From: Angela Jolliffe [REDACTED]
Sent: 27 January 2017 16:43
To: Hilary Kernohan; David Innes
Cc: Claire Potts
Subject: Redraw Pollards Nursery Site BN/66/16/DOC, BN/52/16/Res (51/16)

Further to my previous emails relating to the Redrow Application for a revised layout, please see below relating to the Reptile habitat.

Drawing Number	Rev
700	A

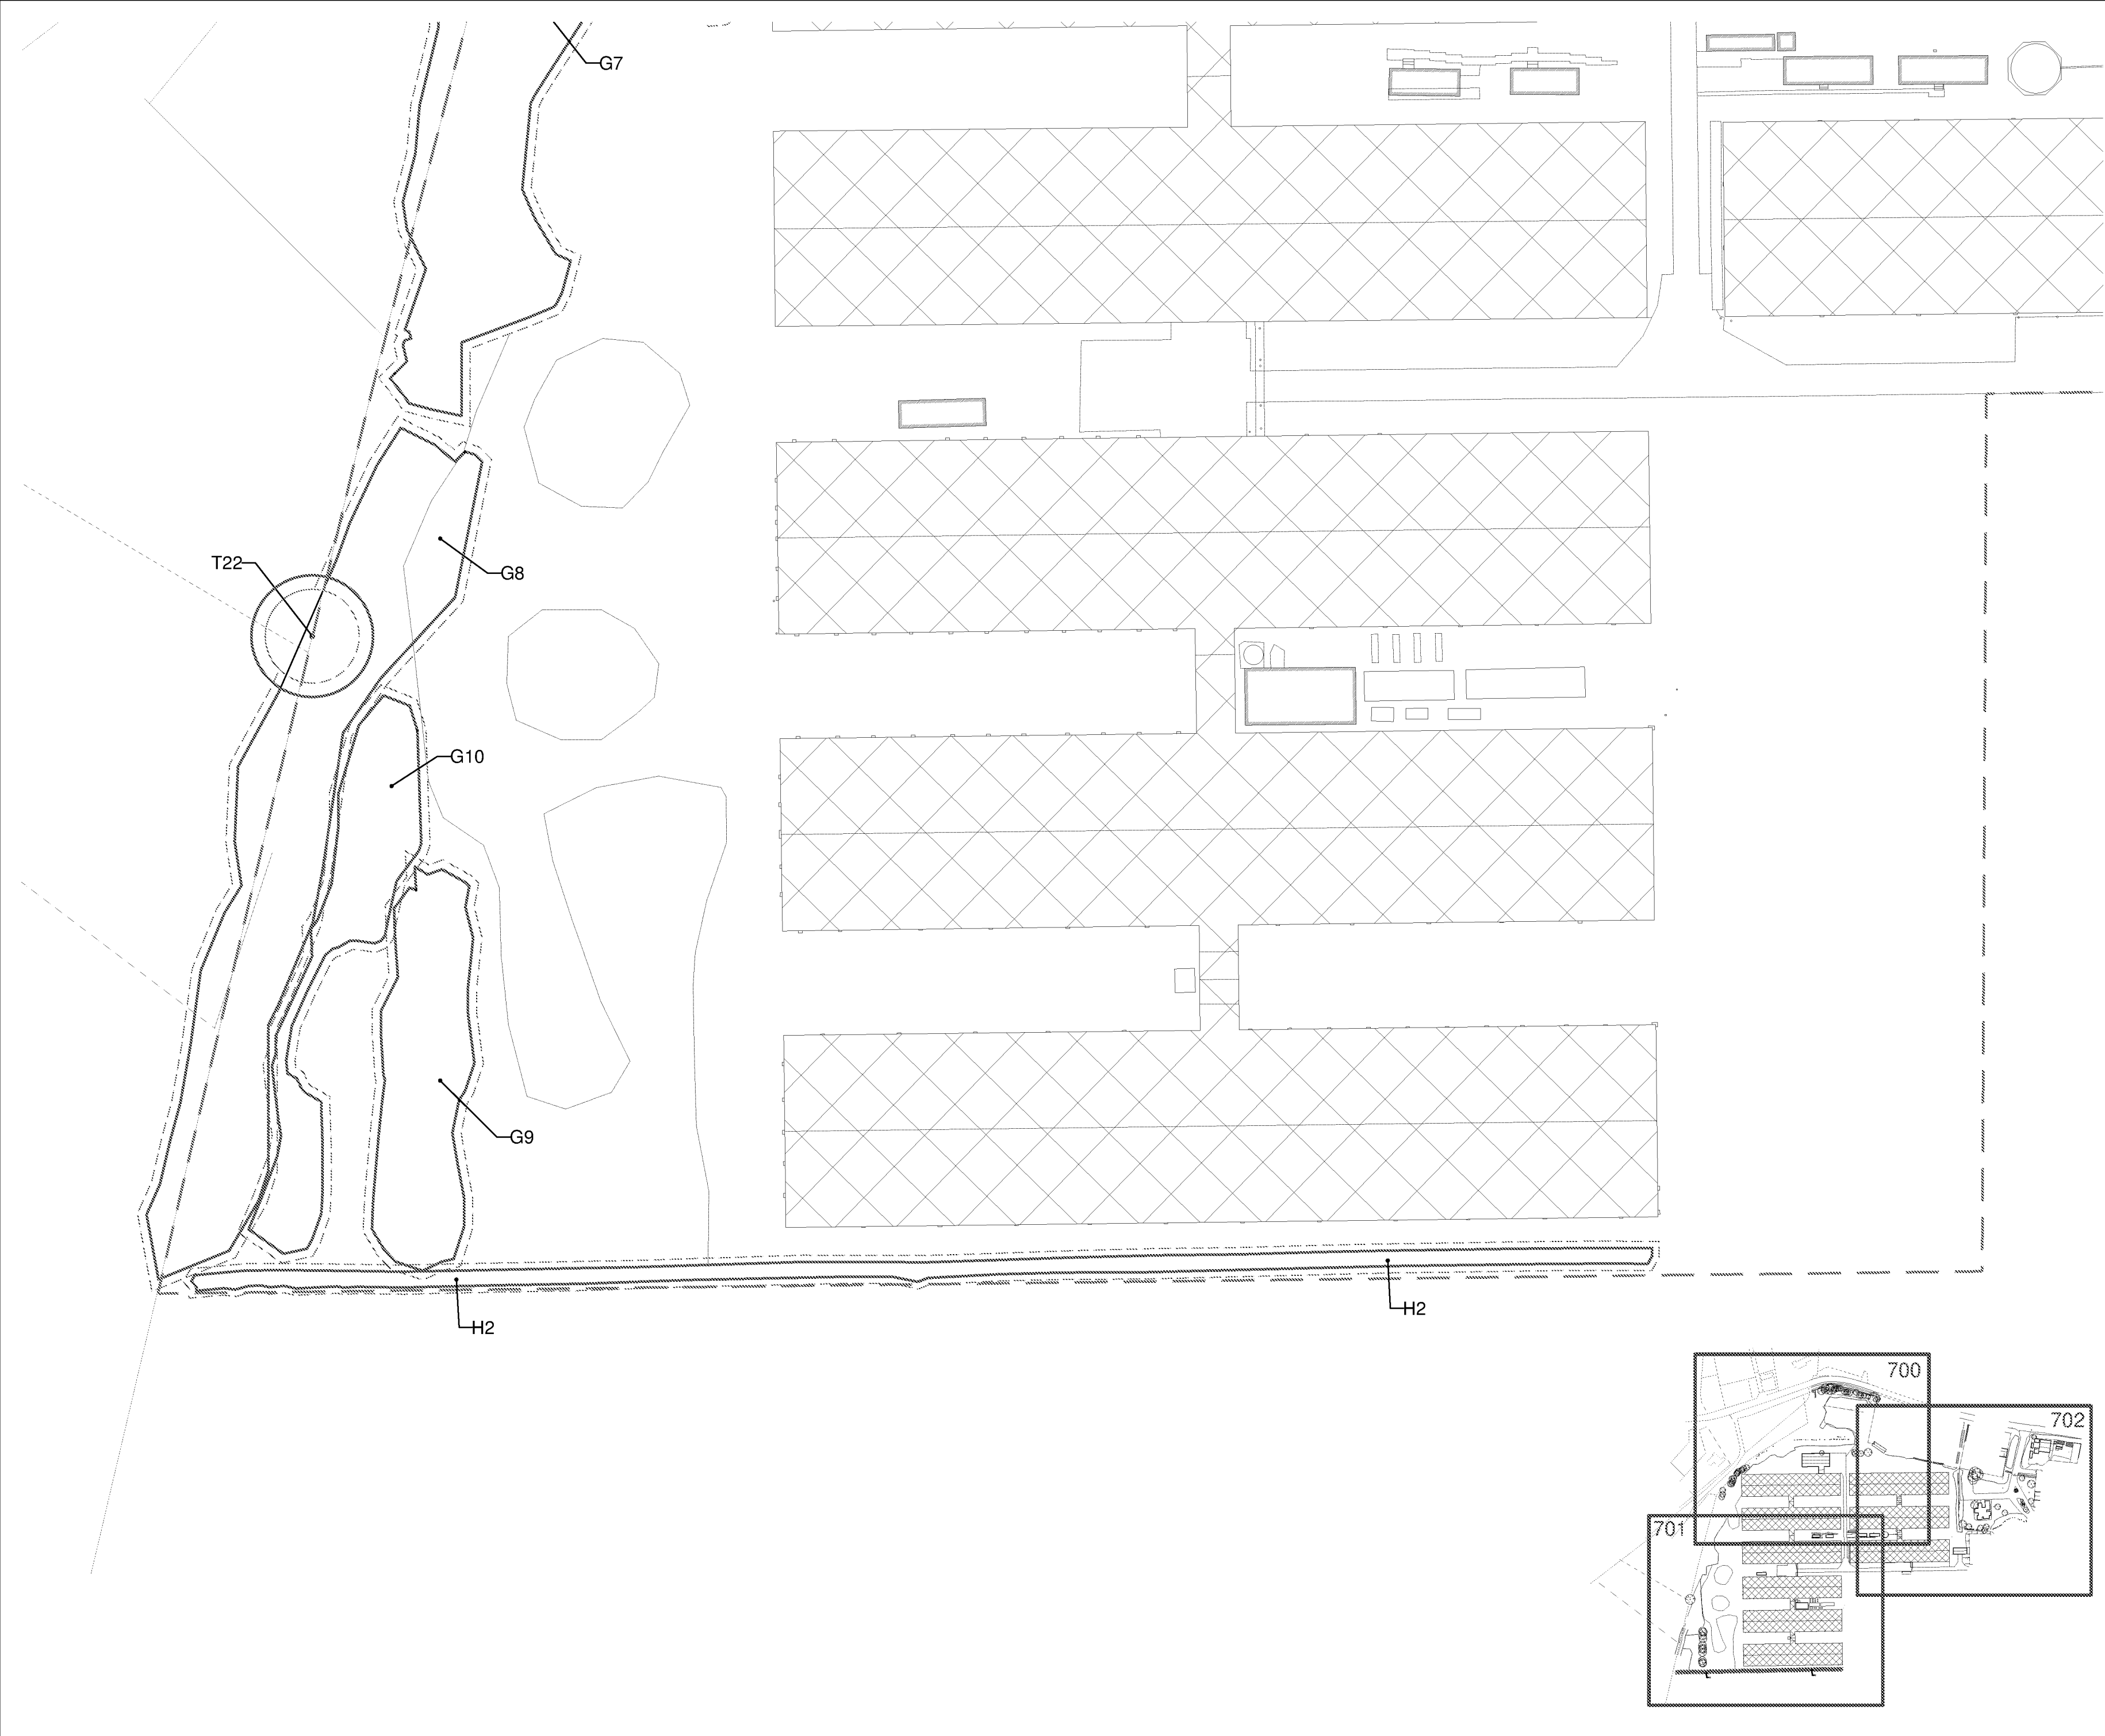
With regards to the Tree T22 on the RPS Drawing 717, dated 15/11/2016, this tree does not appear to be present on the site. I will forward you some current site photos shortly.
